# Rezoning Transportation Analysis

Petition Number: 2020-050

General Location Identifier: Tax ID 14913365

Date	Description
04/22/2020	First Review

TECHNICAL DATA

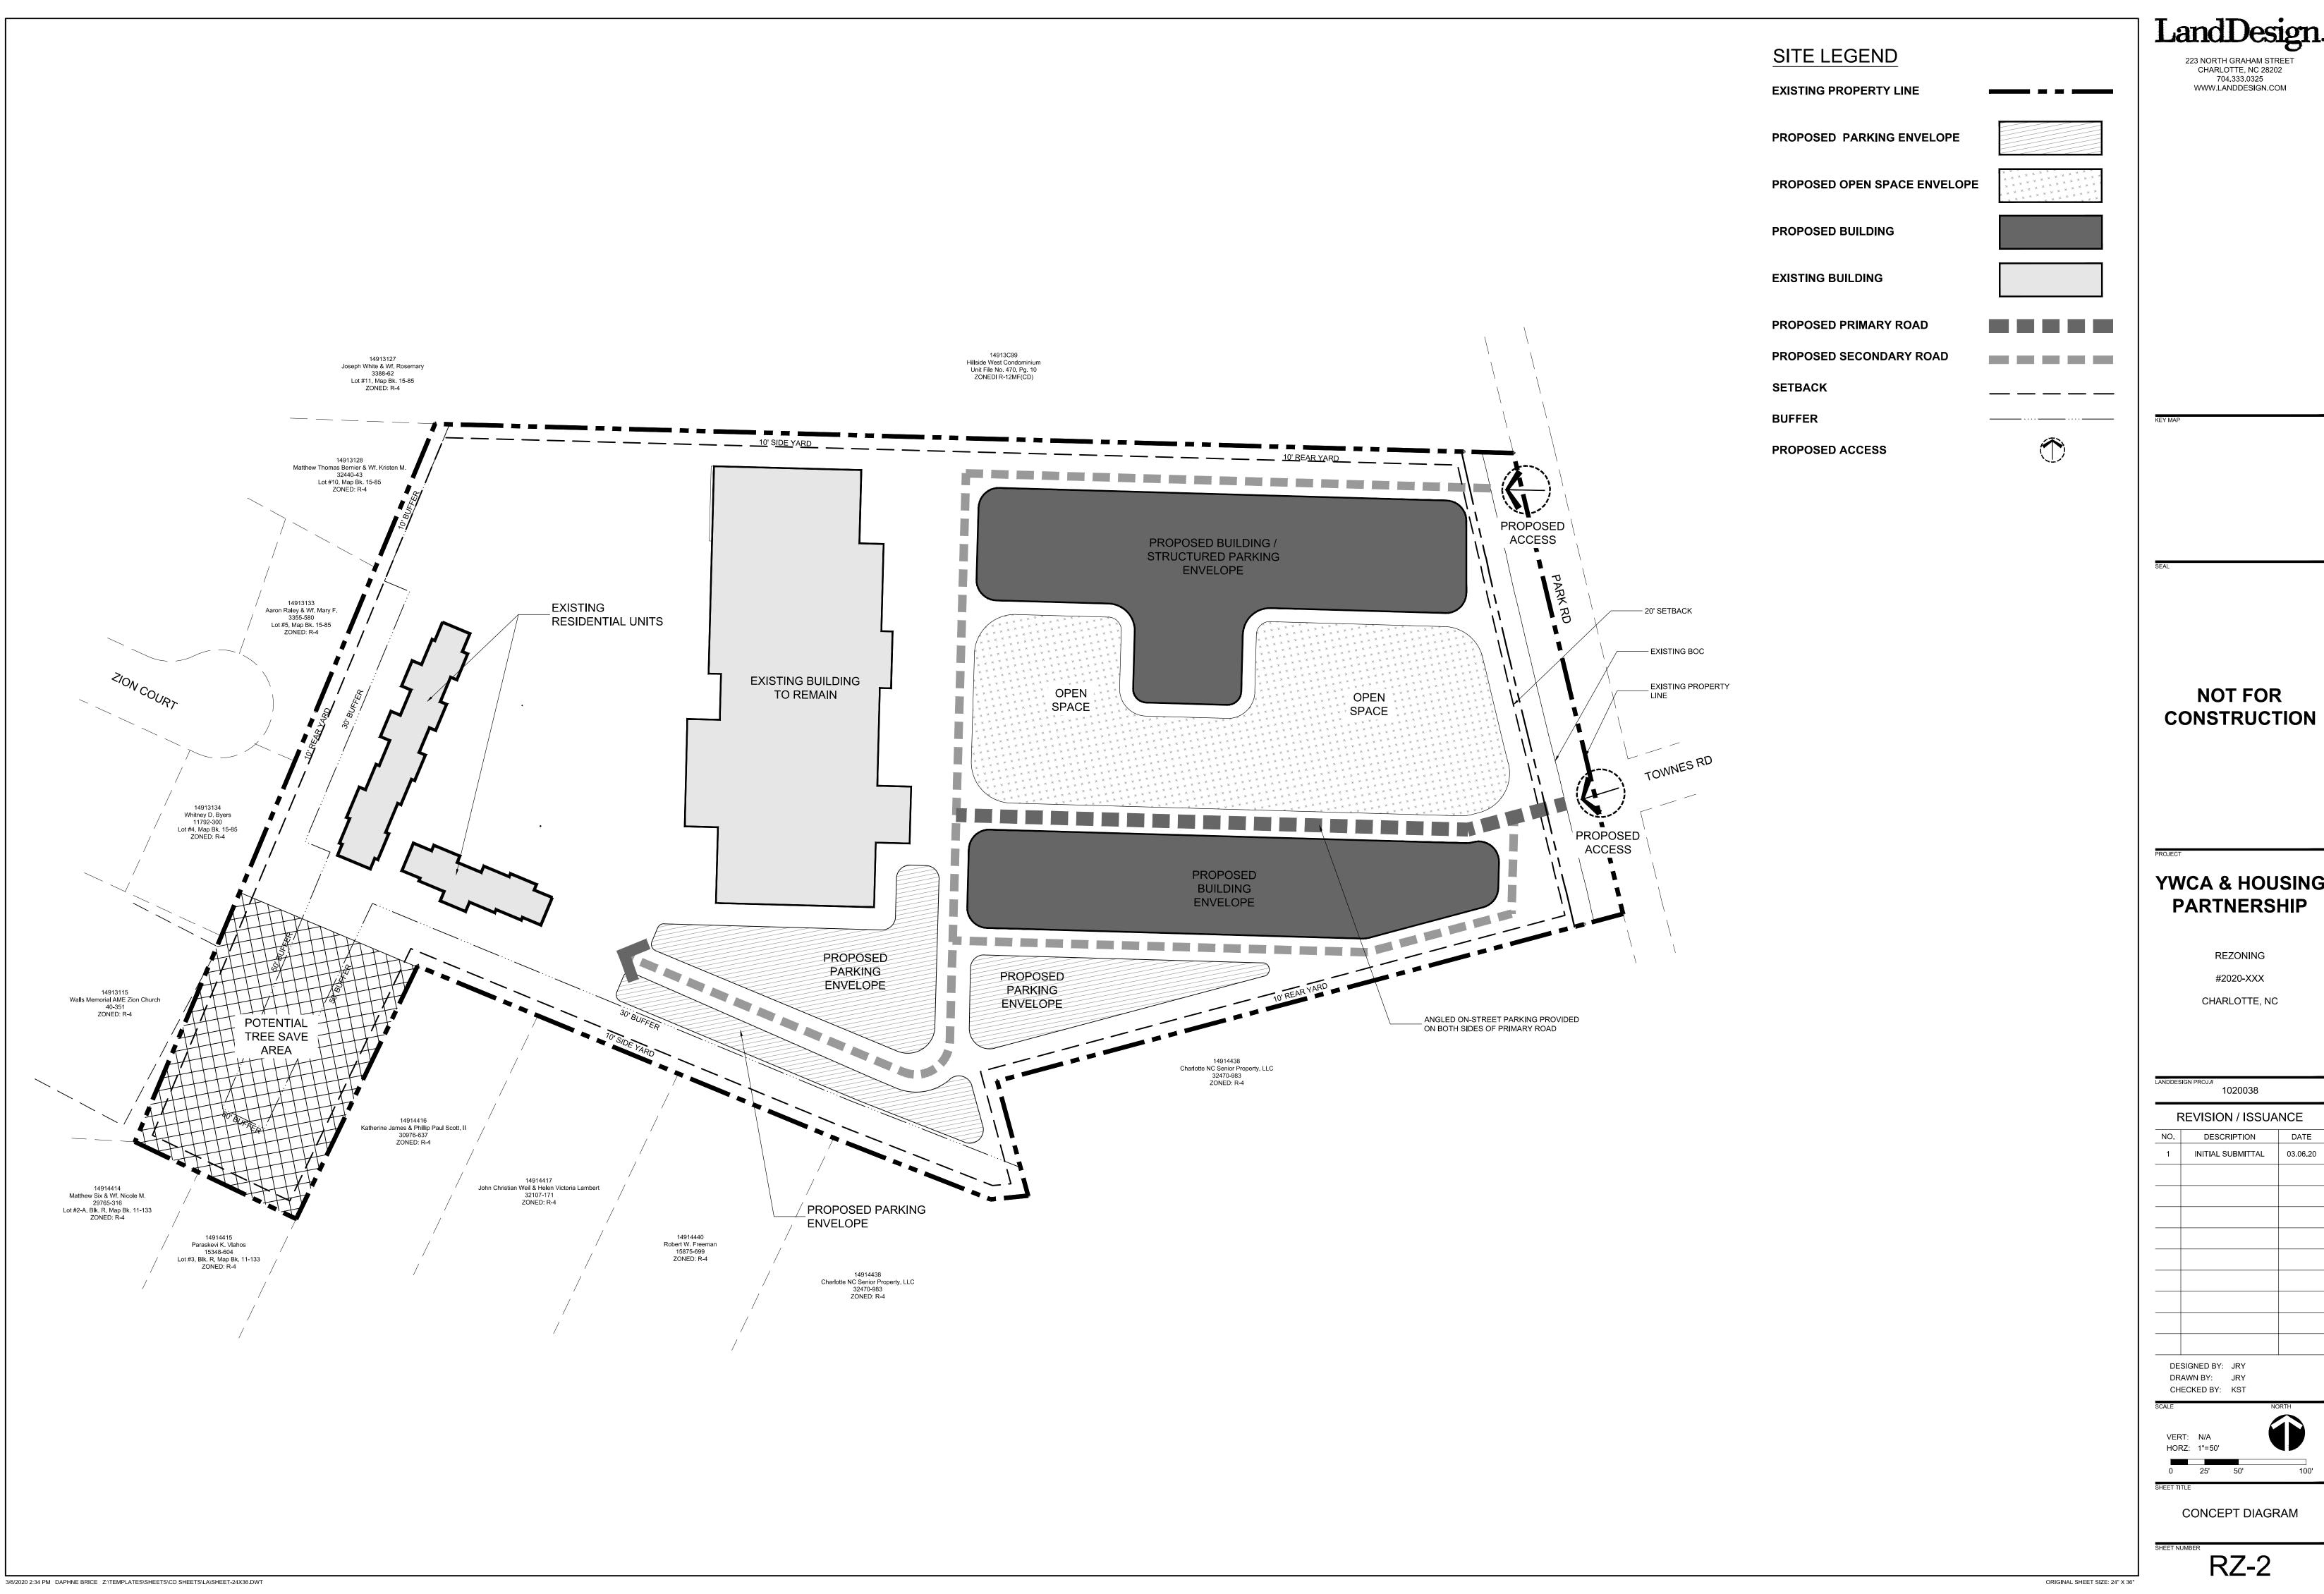
The site plan should show the curb and gutter labeled and dimensioned from the centerline for each road.

3. The petitioner should revise the site plan on Sheet 1 to show the dimensions for the 6-foot sidewalk and 8-foot planting strip and update the conditional note 5.b. to state that the petitioner will commit to construct an 8-foot planting strip, and 6-foot sidewalk on Park Road.

4. The petitioner should revise the site plan and conditional note(s) to indicate the locations of the existing bus stops and pedestrian hybrid beacon in front of the YWCA.

5. The petitioner should revise the site plan to add a note specifying dedication and fee simple conveyance of all rights of way to the City before the site's first building certificate of occupancy is issued. CDOT requests right of way set at 2' behind back of sidewalk where feasible.

6. The petitioner should revise the site plan to add a note specifying all transportation improvements will be approved and constructed before the site's first building certificate of occupancy is issued.
